COMMUNITY SERVICES DEPARTMENT
PARK OPERATIONS ~ ENVIRONMENTAL SERVICES ~ RECREATION/CULTURAL SERVICES

May 31, 2022

Subject: Meadow Lake Commercial Park Rezone (CS-221)

CS REZONE LEGAL DESCRIPTION

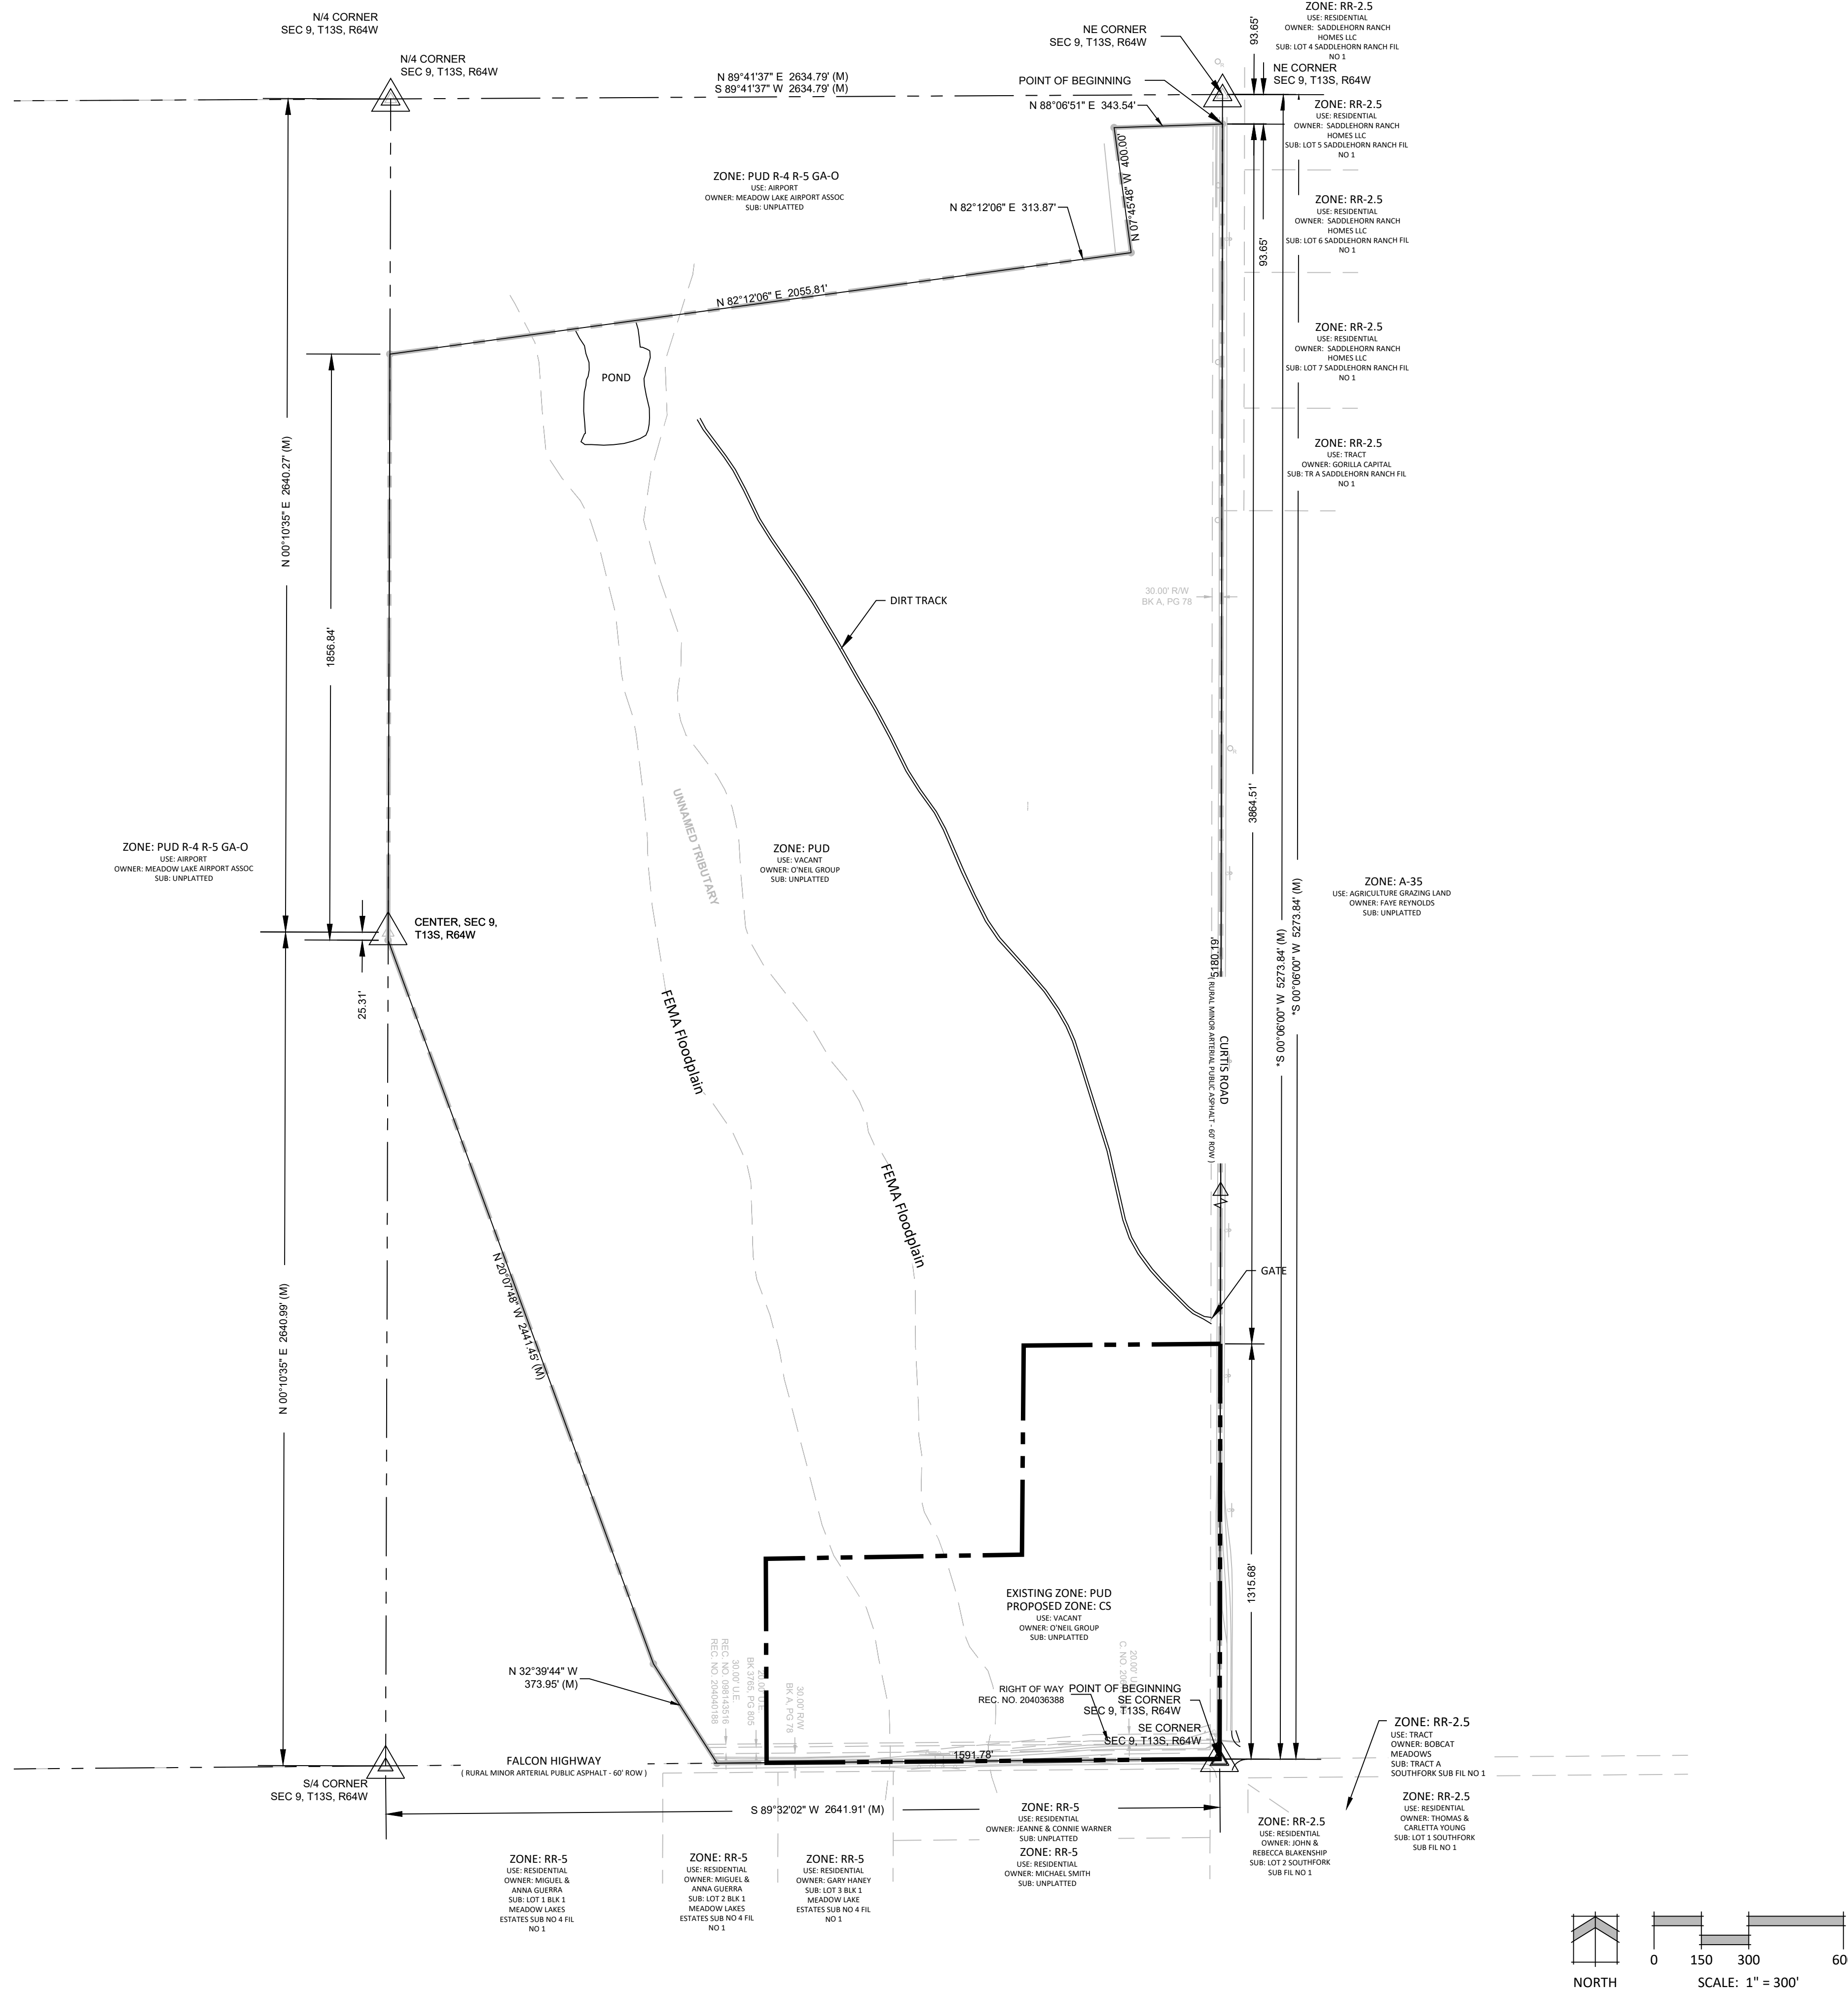
County Parks requests trail easements where development projects impact proposed County trails. As it pertains to this application, the County requests that the landowner provide a 25-foot public trail easement along the west side of Curtis Road that allows for the construction and maintenance by El Paso County of a secondary regional trail, and this easement shall be shown and dedicated to El Paso County on the Final Plat.

Recommend that the Planning Commission and the Board of County Commissioners include the following conditions when considering and/or approving the Meadow Lake Commercial Park Rezone: (1) No regional park fees are recommended, as the Board of County Commissioners has elected to not require park fees for commercial subdivisions (2) Dedicate and provide to El Paso County a 25-foot public trail easement along the west side of Curtis Road that allows for the construction and maintenance by El Paso County of the Judge Orr Secondary Regional Trail, and this easement shall be shown and dedicated to El Paso County on the future Final Plat.
